WEST SUSSEX COUNTY COUNCIL CONSULTATION

TO:	Arun District Council FAO: Amber Willard
FROM:	WSSC - Highways Authority
DATE:	17 February 2022
LOCATION:	Land Adjacent to 18 Queens Lane Arundel BN18 9JN
SUBJECT:	AB/136/21/PL Demolition of garage and erection of two dwellings with associated car parking and landscaping. This application is in CIL Zone 2 and is CIL liable as new dwellings.
DATE OF SITE VISIT:	n/a
RECOMMENDATION:	Advice
S106 CONTRIBUTION TOTAL:	n/a

PROPOSED BLOCK PLAN
SCALE 1:500

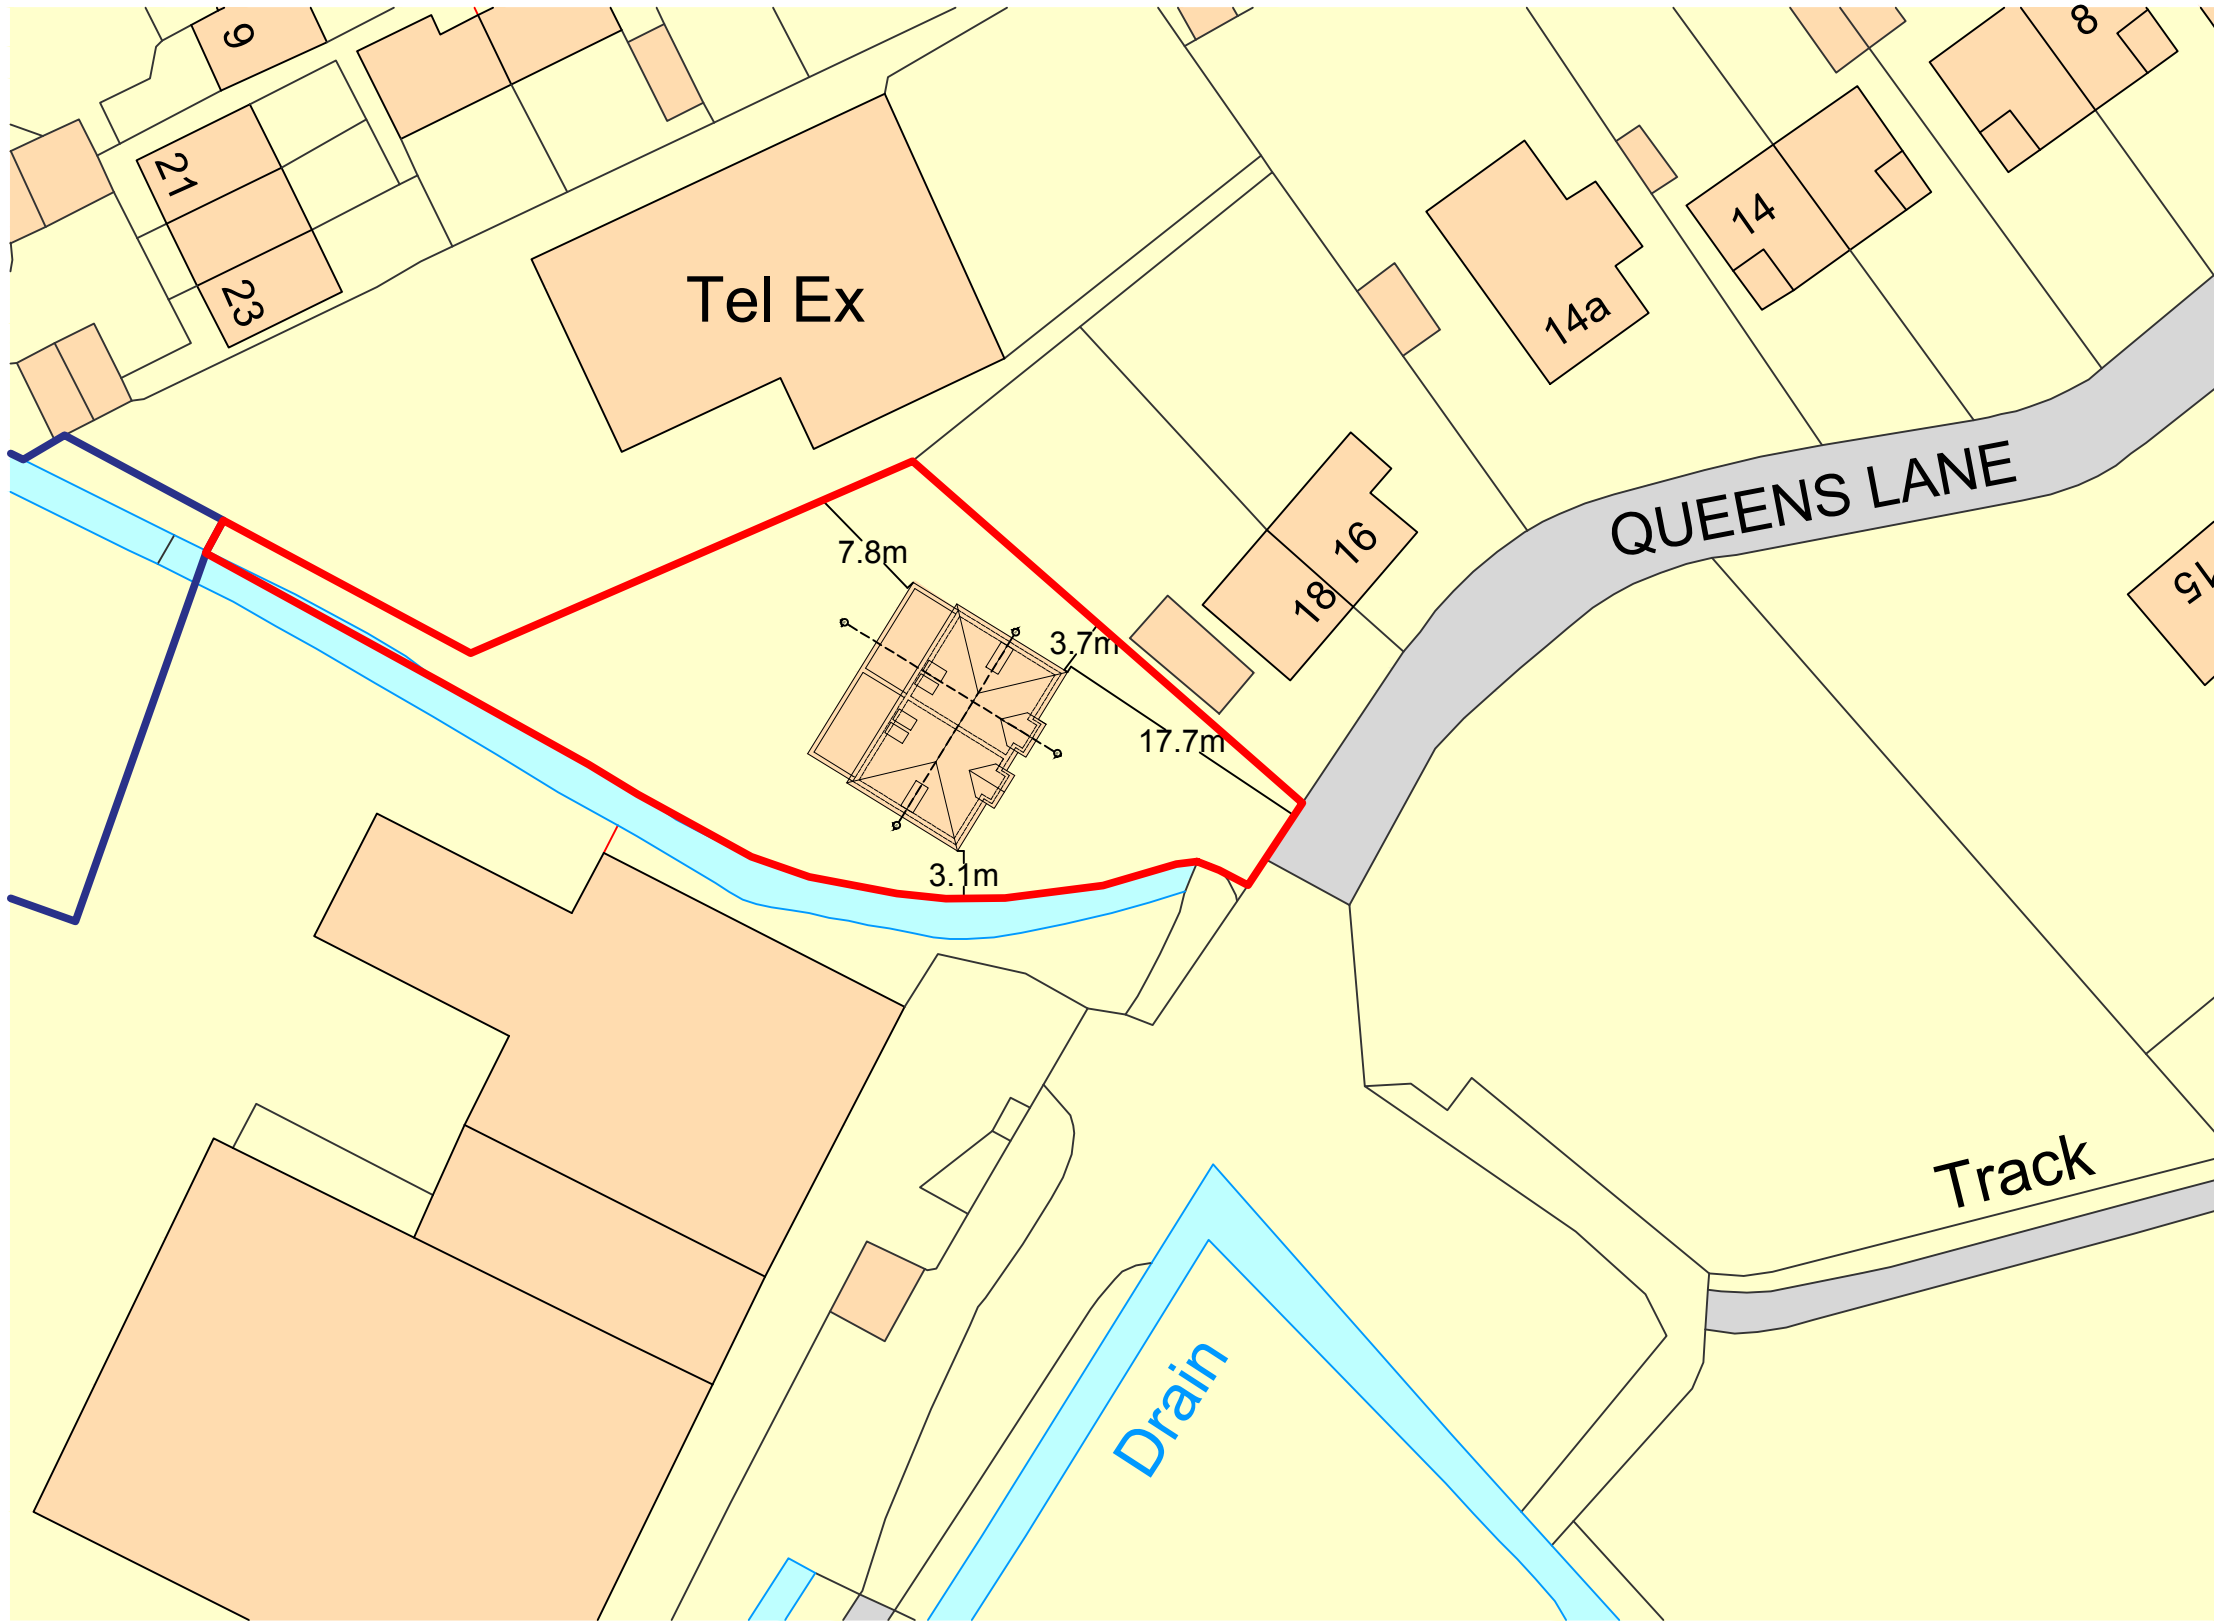
The applicant has provided 2 garages (1 per dwelling) measuring 3 x 5.5 metres and no clear hardstand for parking. No Cycle or EV parking details have been provided.

Though not a highways safety or capacity concern, the LPA and applicant may wish to review their parking provisions against The Arun Standards. Details of which could be secured with a suitably worded condition, with details to be provided.
